STATE OF NORTH CAROLINA
DEPARTMENT OF TRANSPORTATION

Addendum No. 1

RE: Contract ID C203632

Railroad Bypass of Pembroke

P-4900A EC-07A

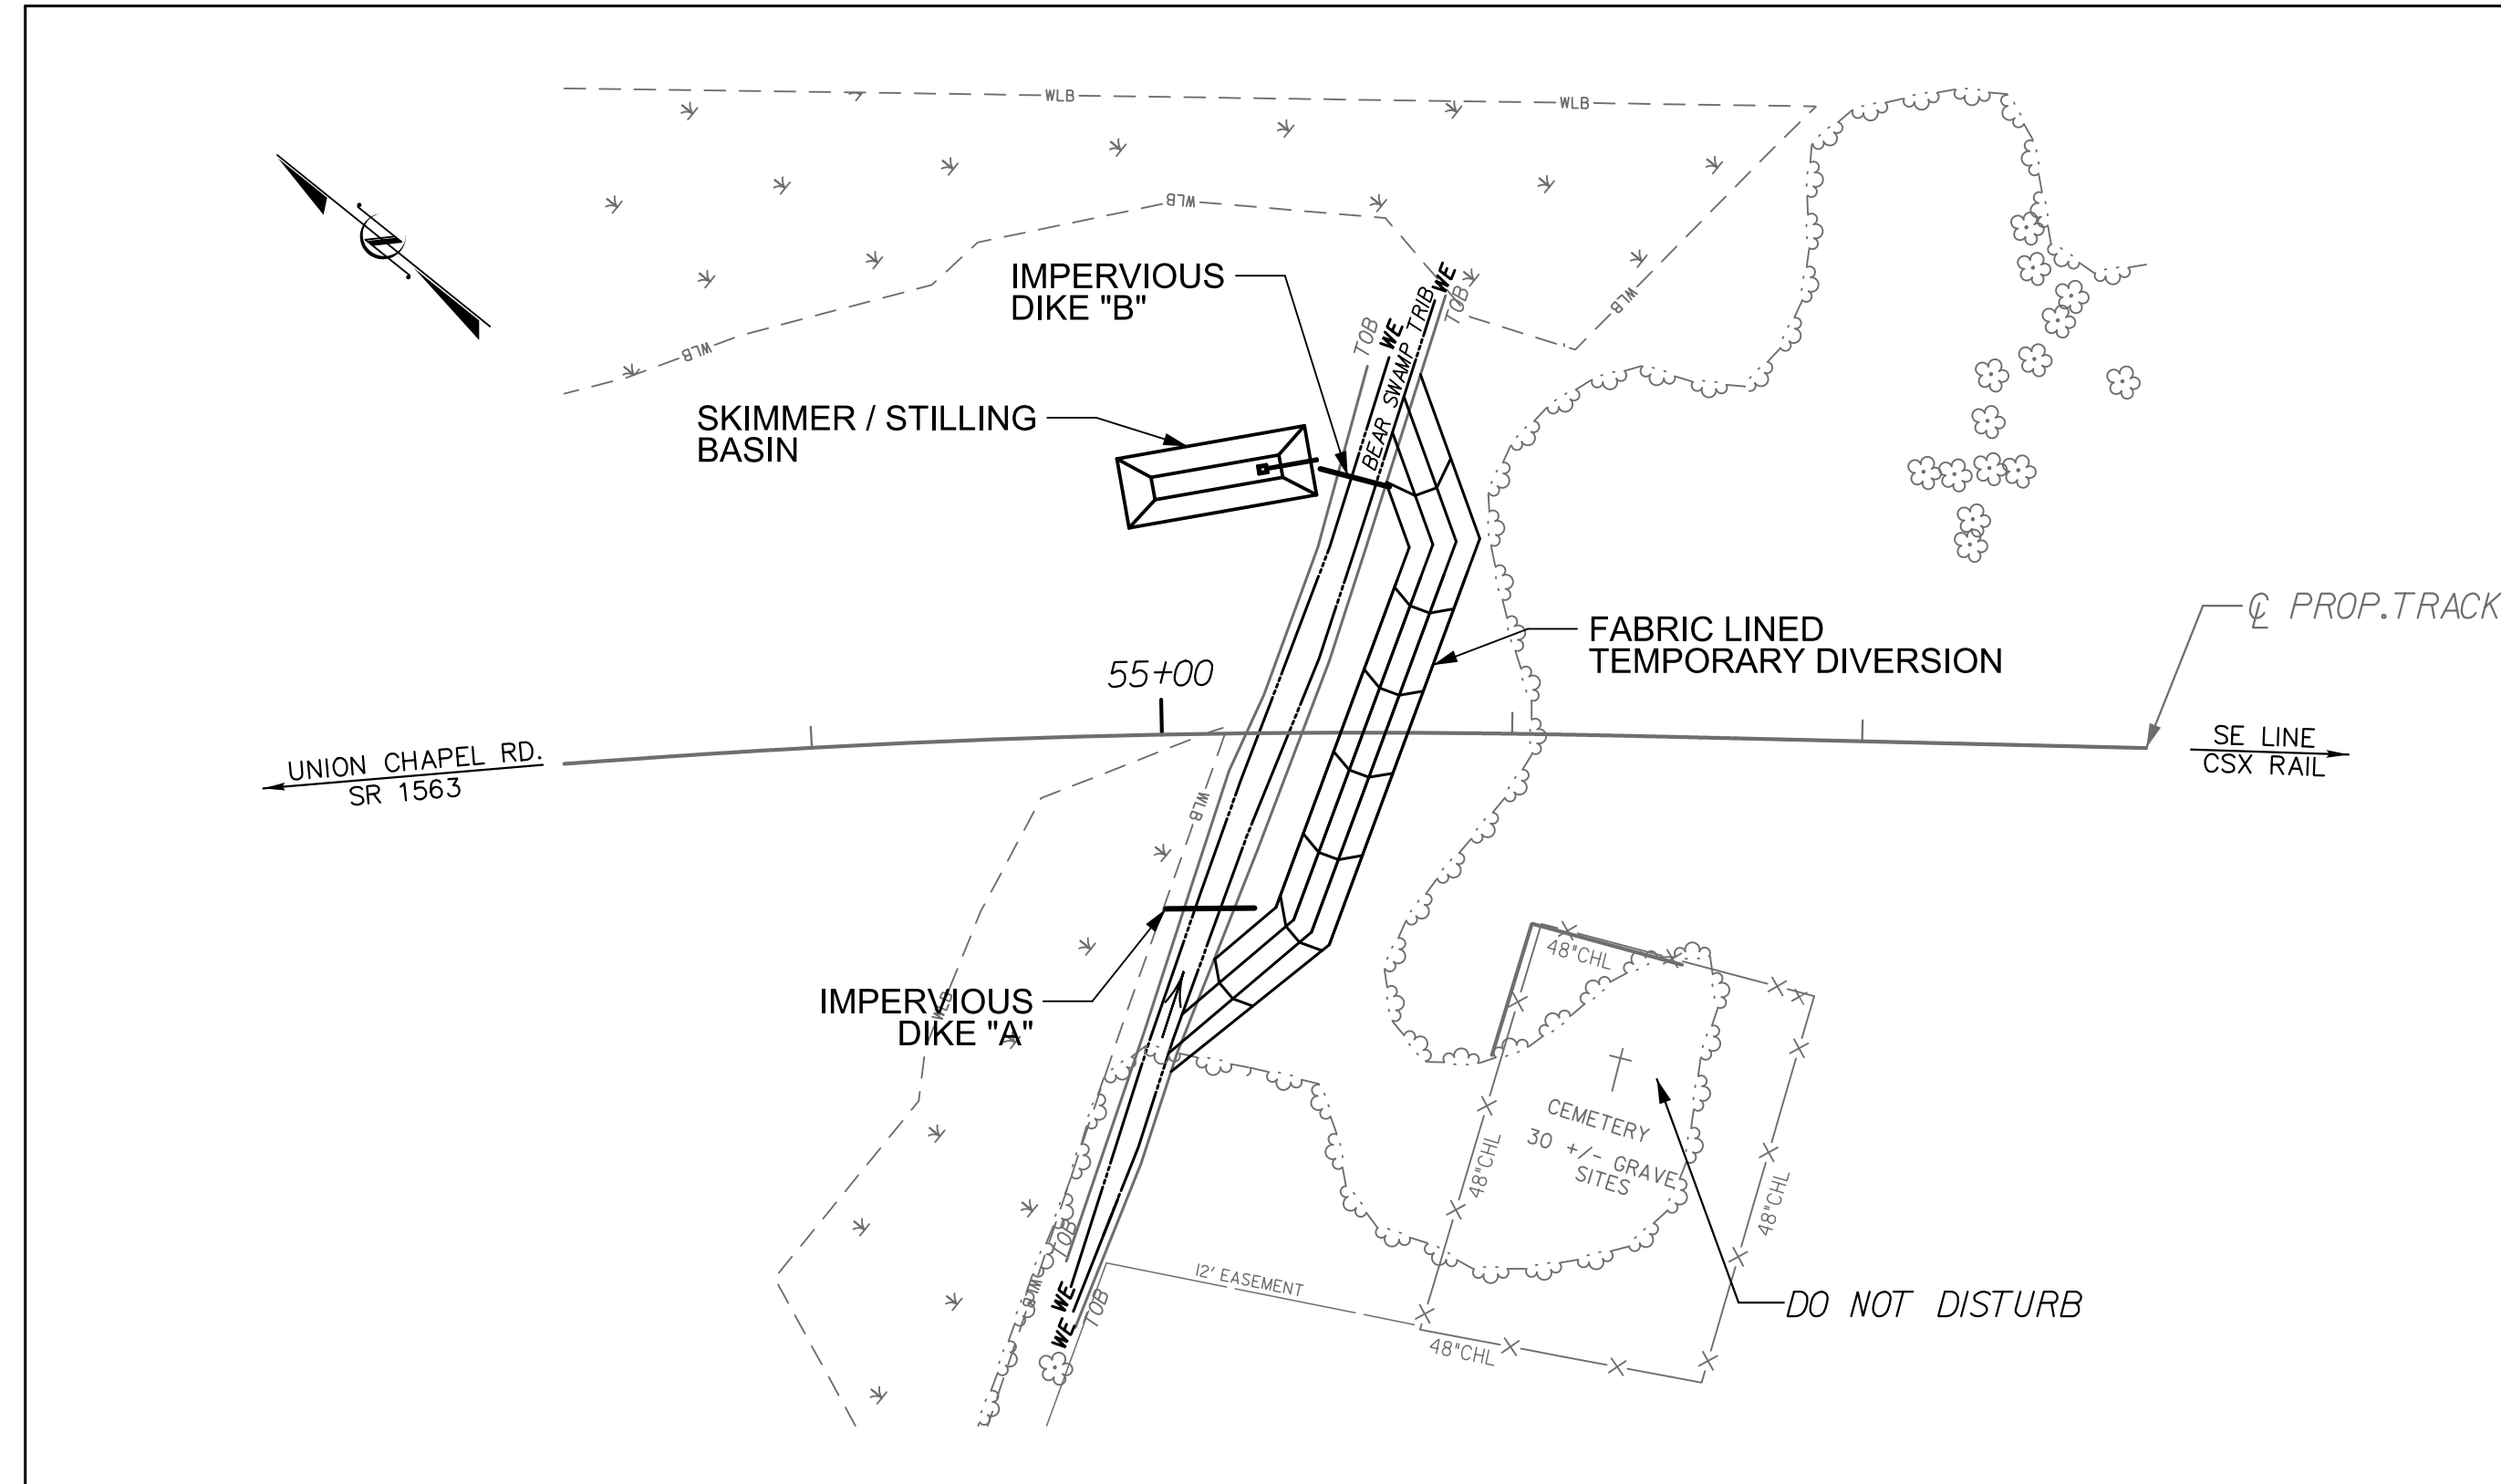
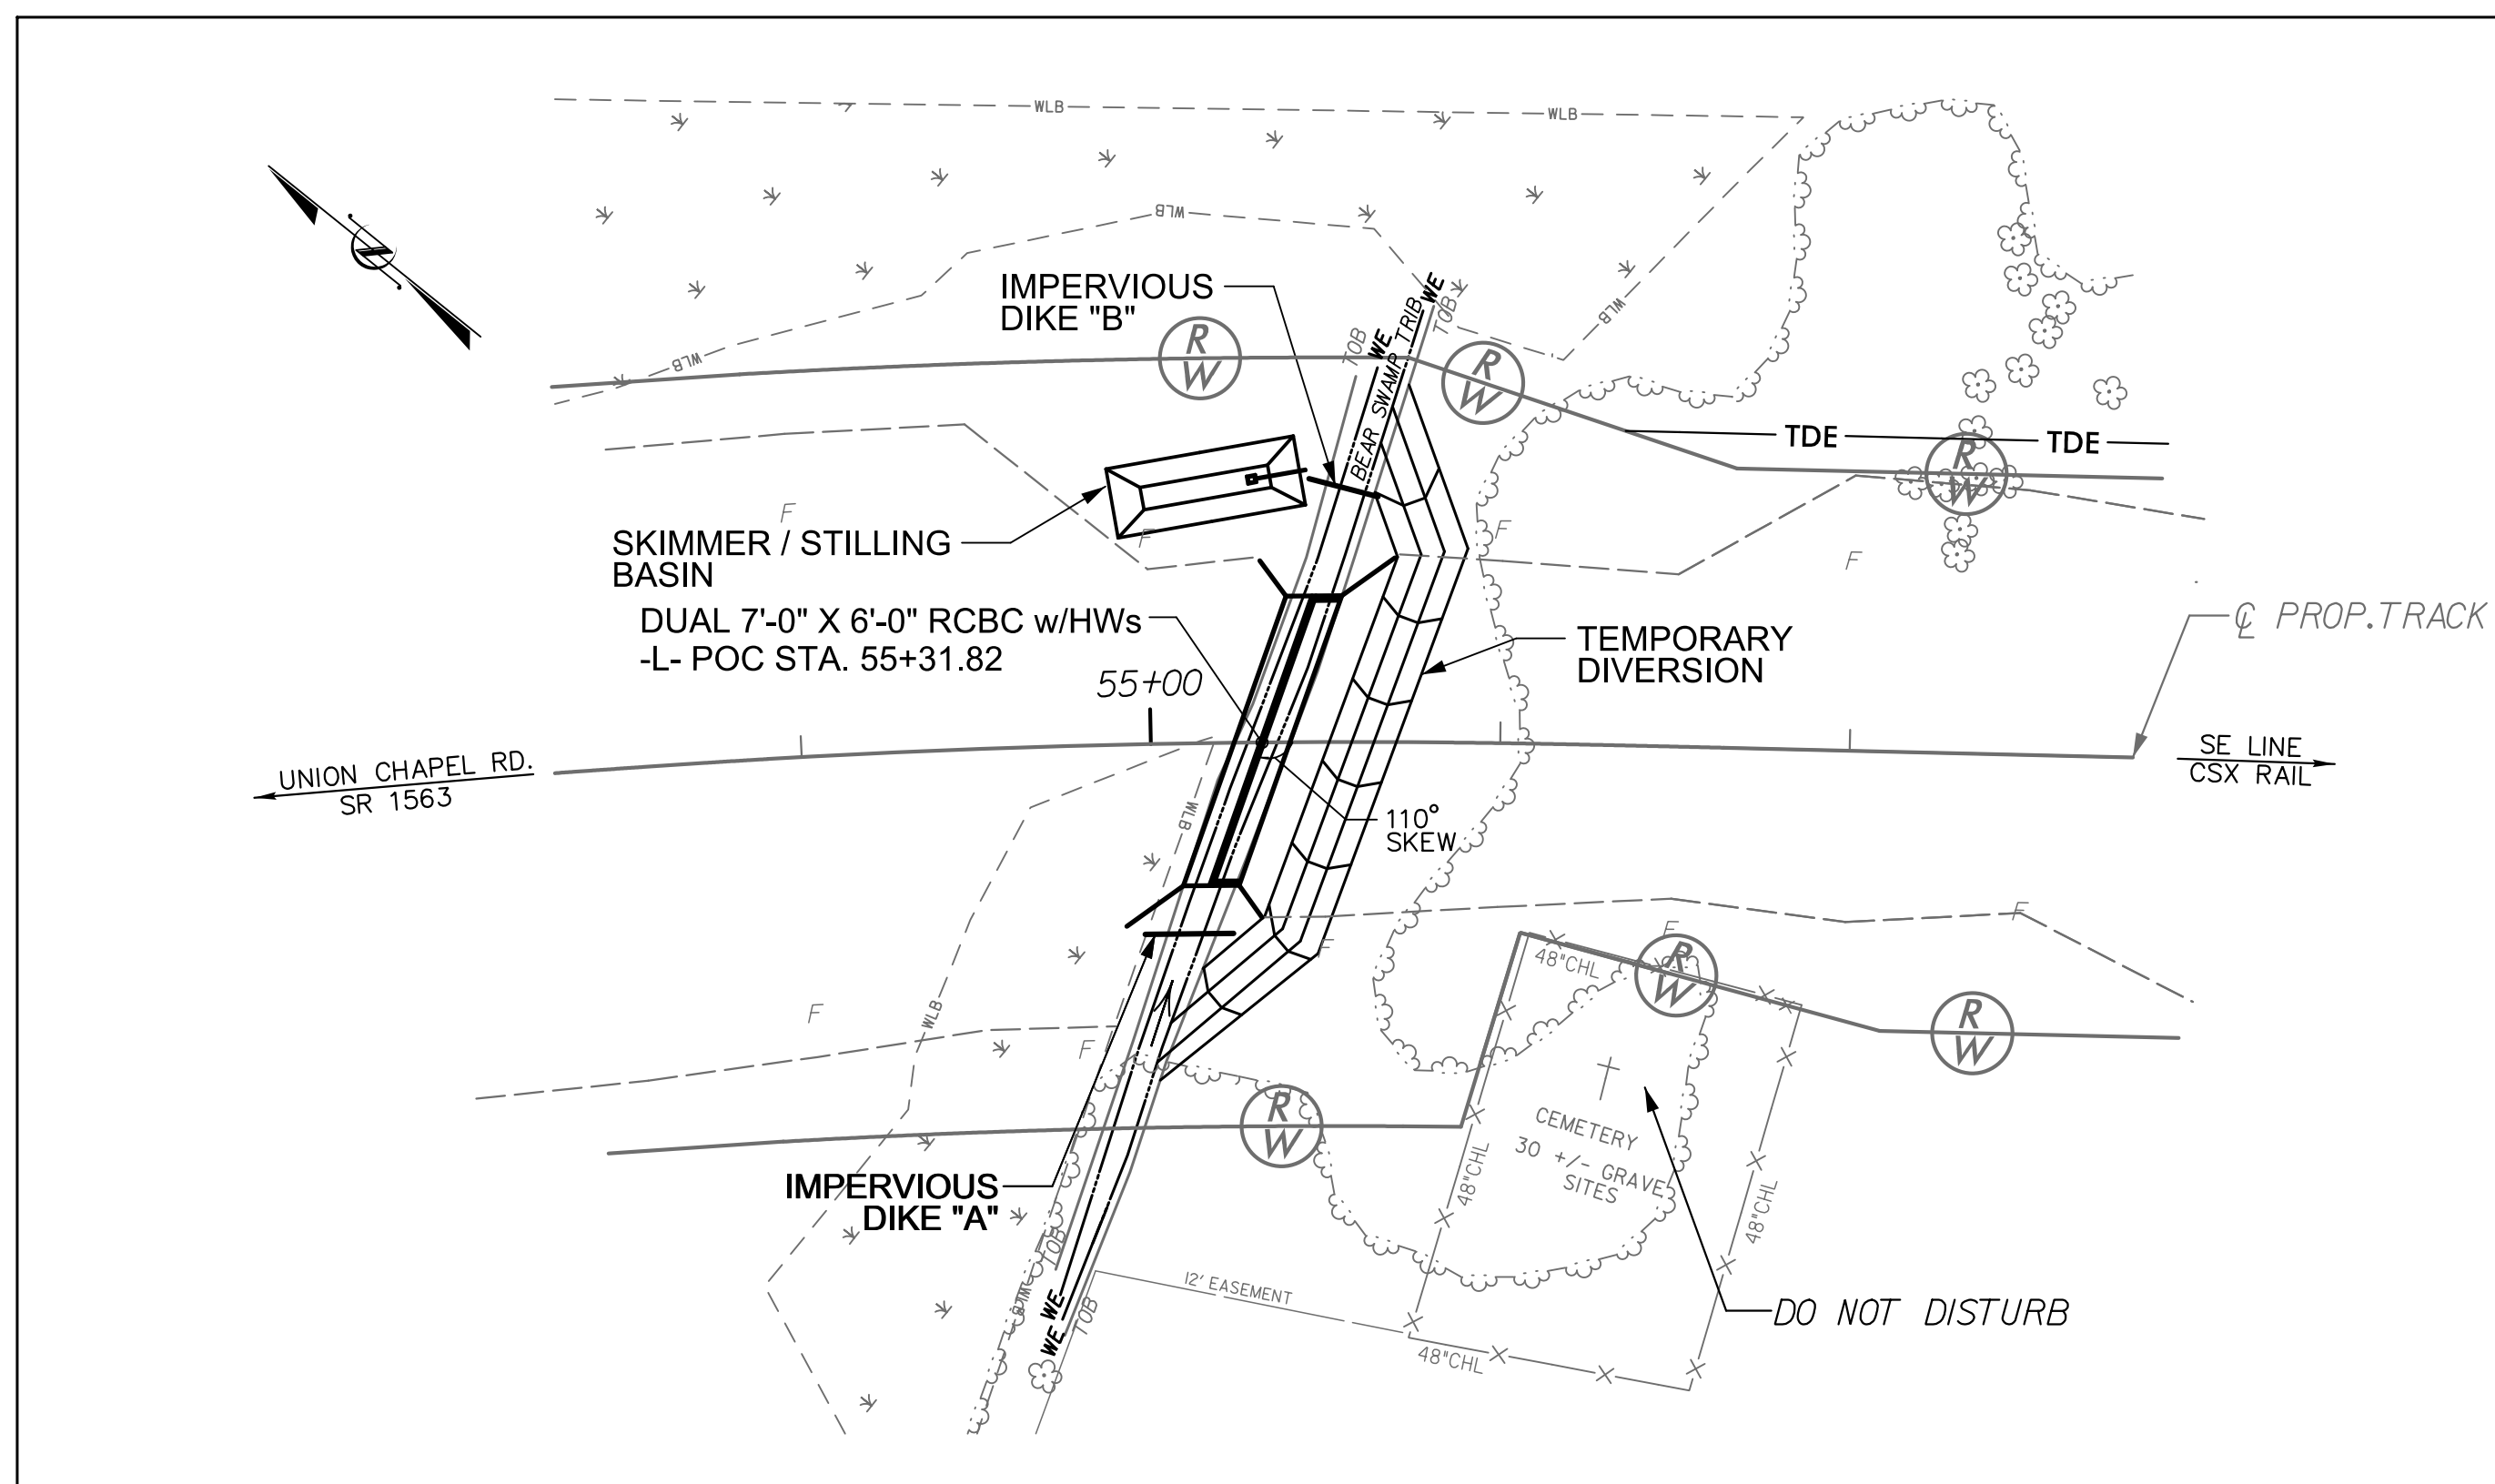
| Sheet No. | Revisions |
|-----------|---|
| EC-07A | New sheet added to describe the culvert phasing for the culvert constructed at Bear Swamp Tributary. Please add new sheet No. EC-07A after existing Sheet No. EC-07 |
